CITY OF ALBUQUERQUE

**Re: Cantata at the Trails, Grading Plan
Engineer's Stamp Date 10/2/12 (C09/D001B)**

Sheet No.:  
**C2.04**

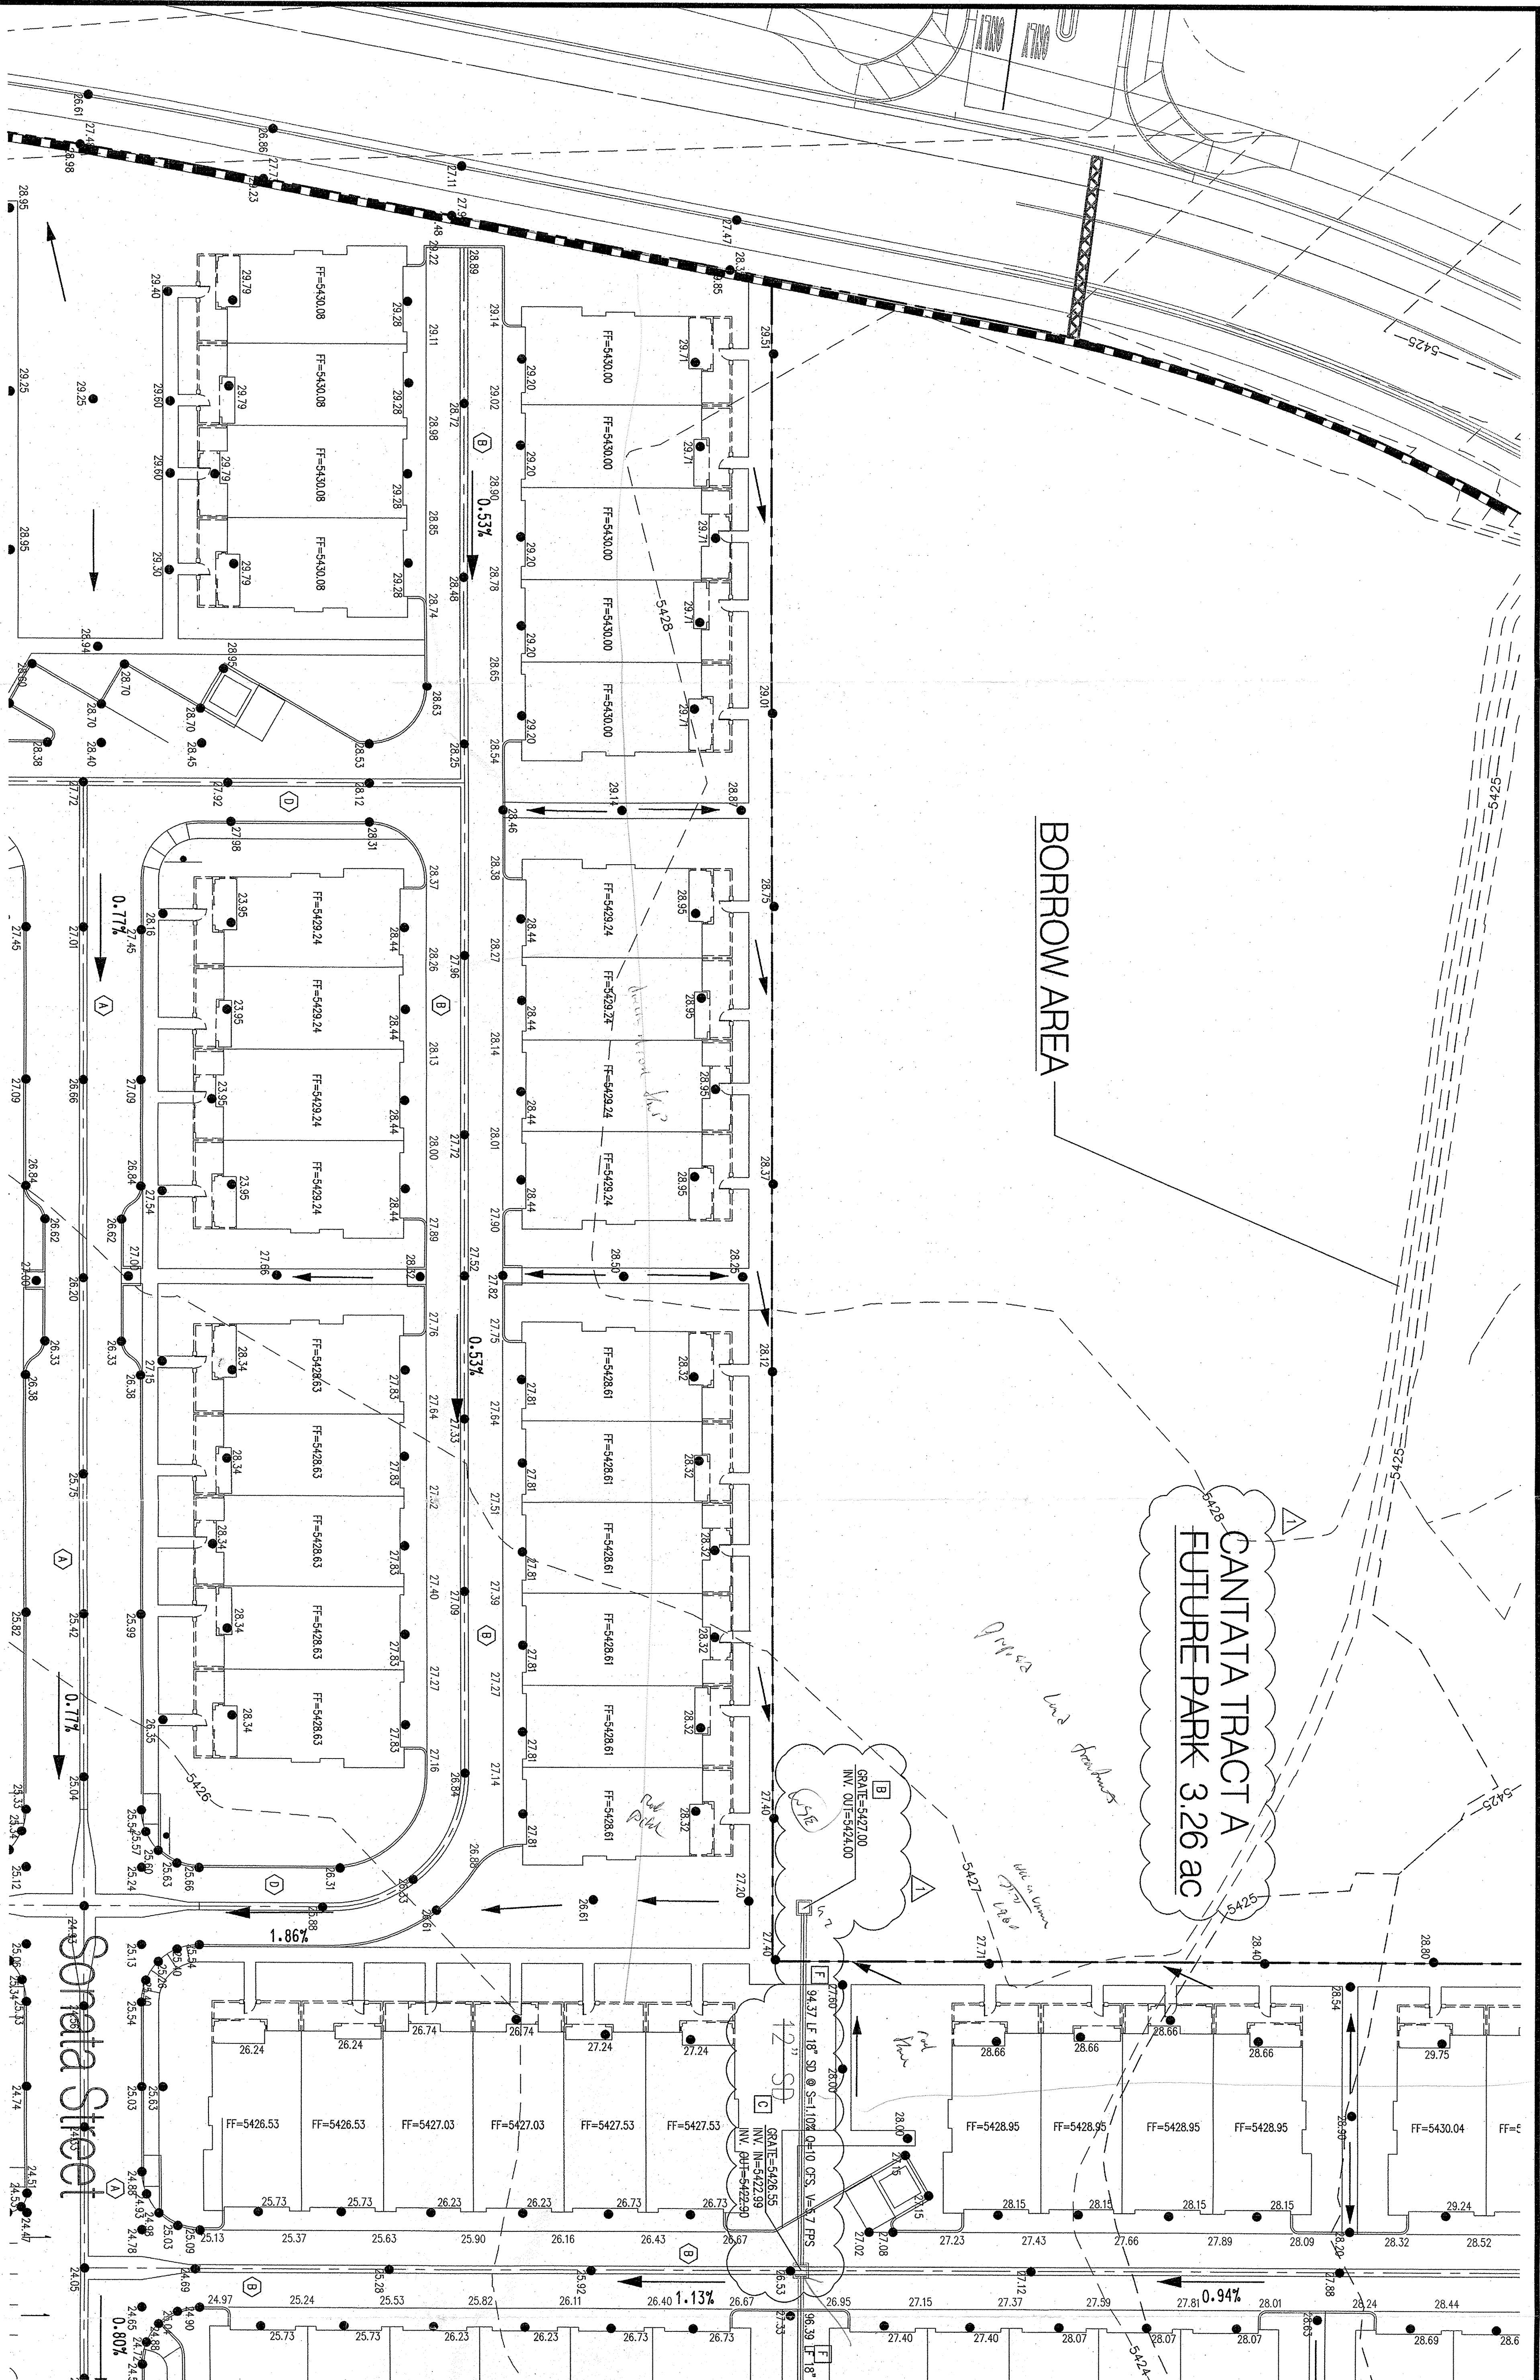
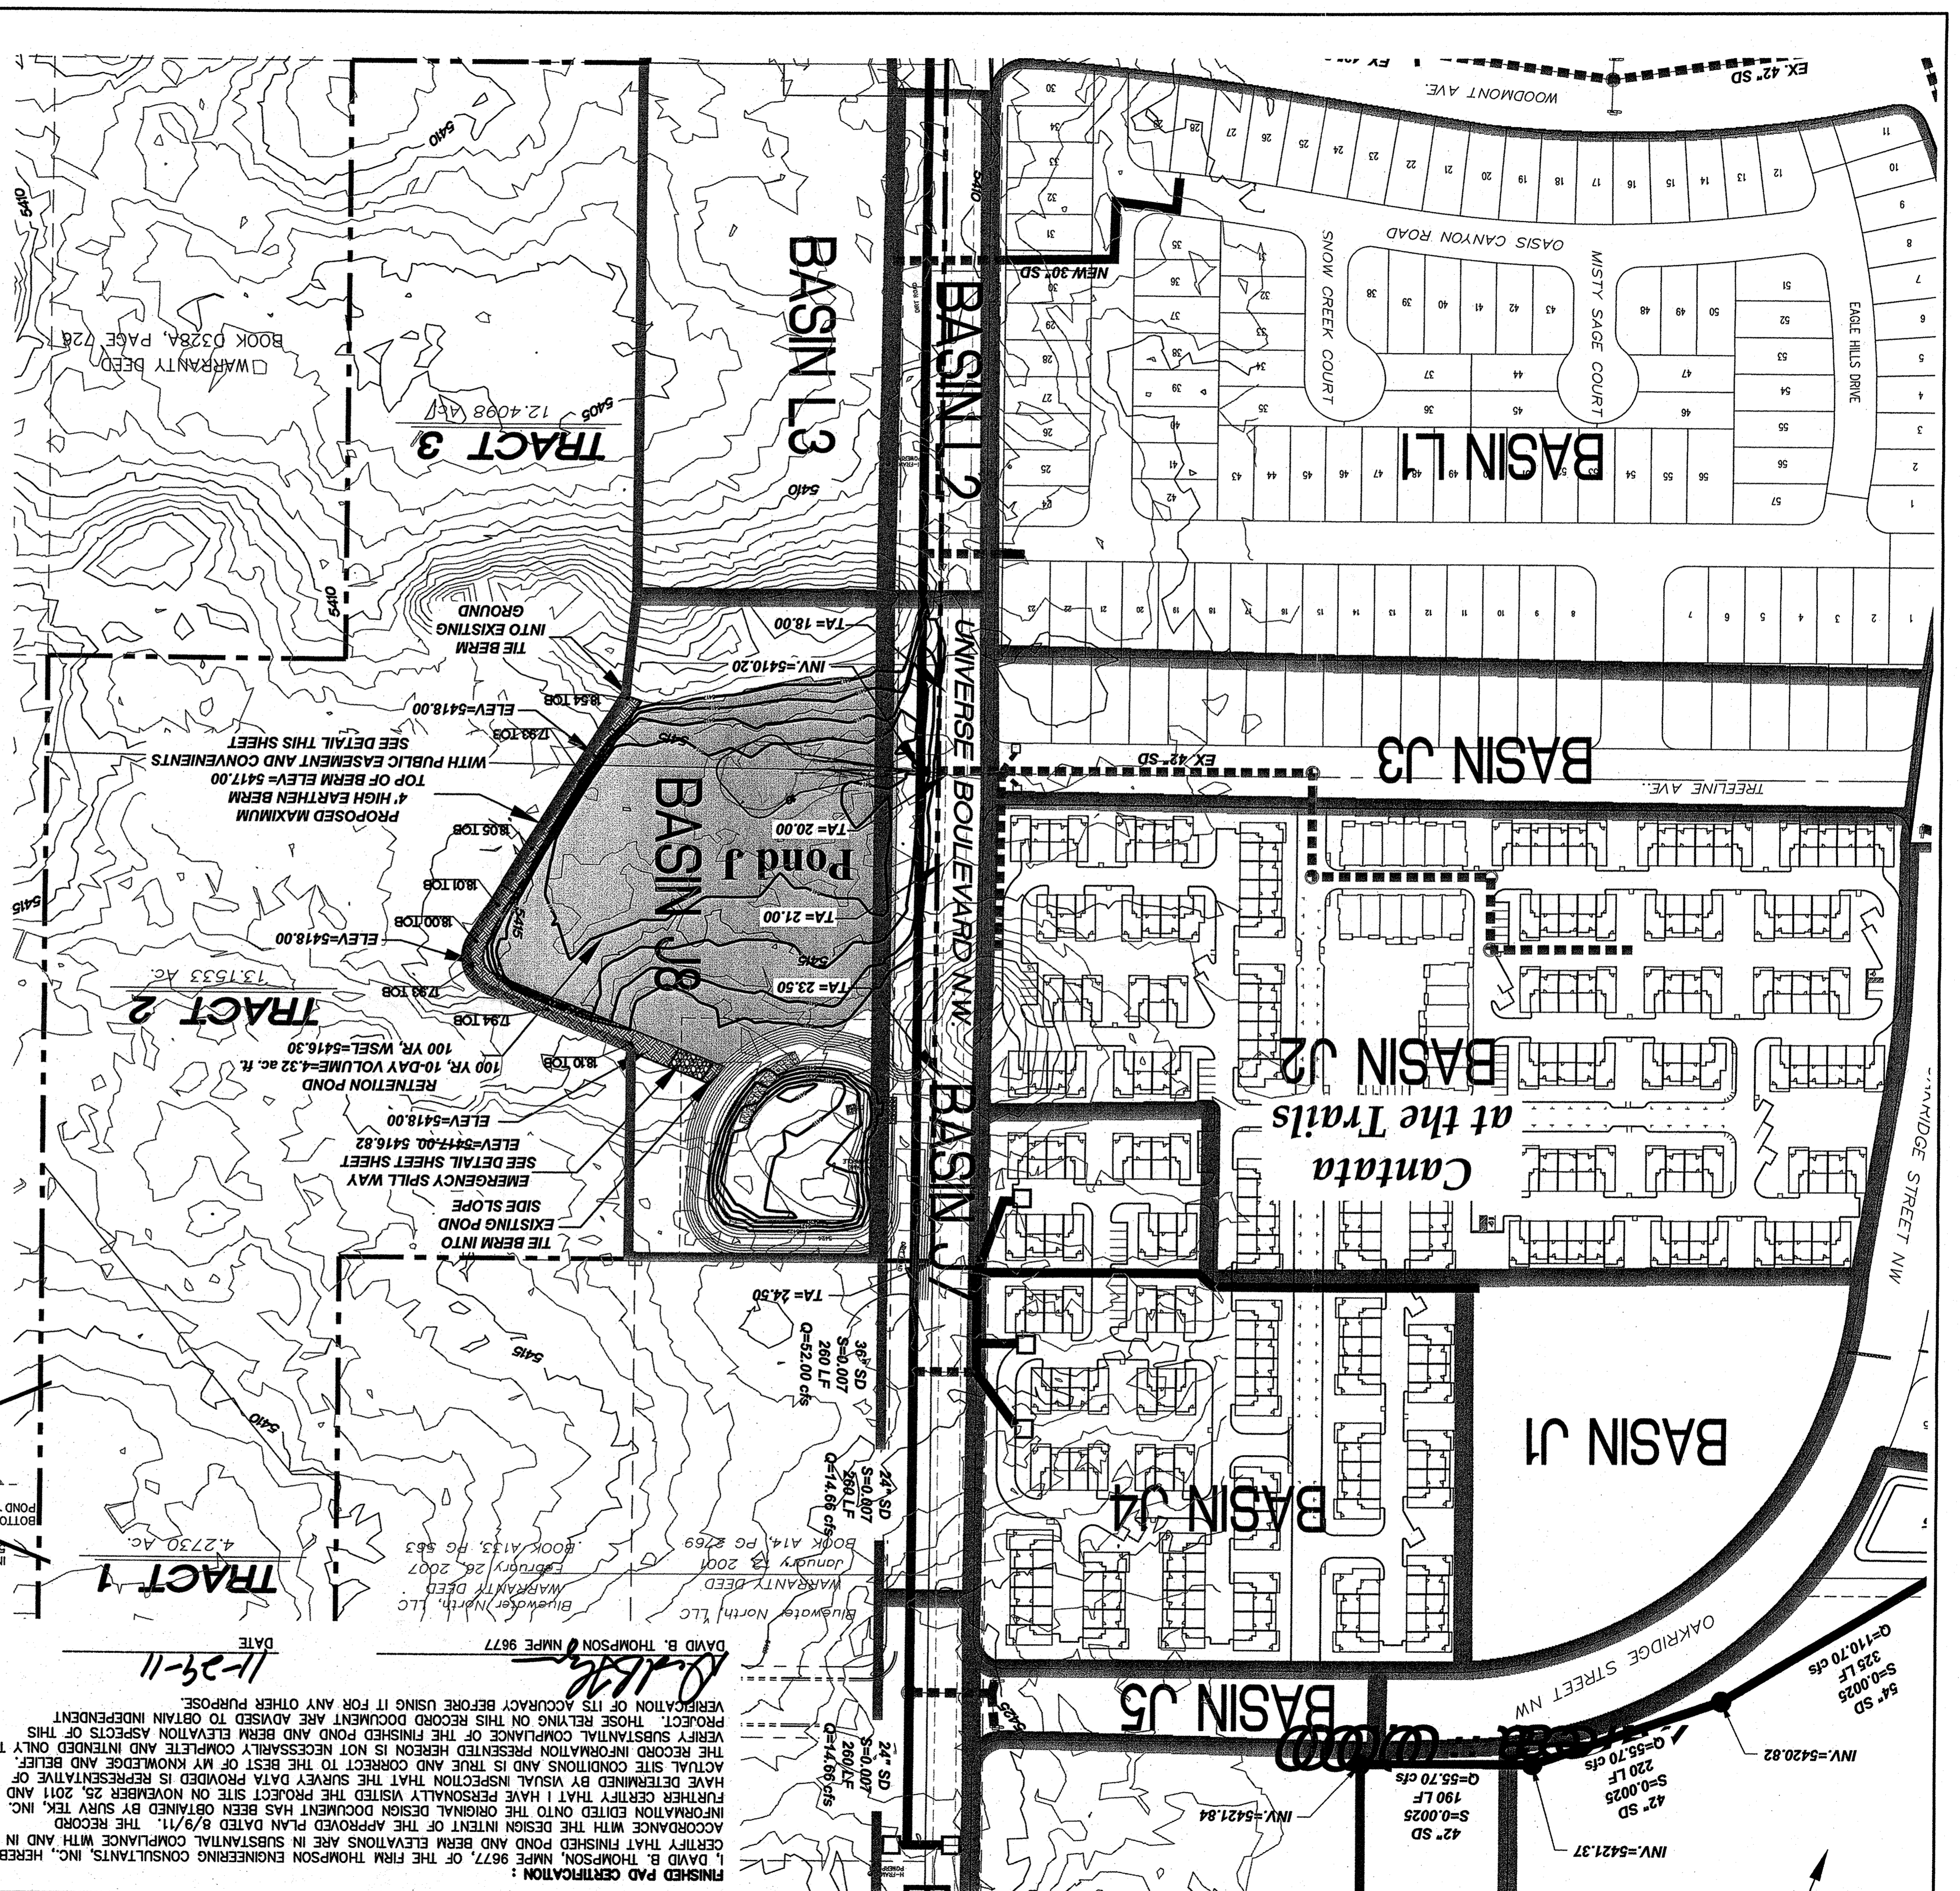
- The contributing basin is larger than Tract A as it includes half a building width south and east of Tract A. This area should be included in the analysis.
- It appears the limited capacity is due to the storm drain west of the manhole at Universe. Provide an analysis with the storm drains upsized one pipe size west of the manhole at Universe.
- A graphical presentation of the HGL requires less time to review and provides more clarity than the tabulated presentation.
- It is not obvious how the proposed ponding would be accomplished with the product that is currently marketed at Cantata.
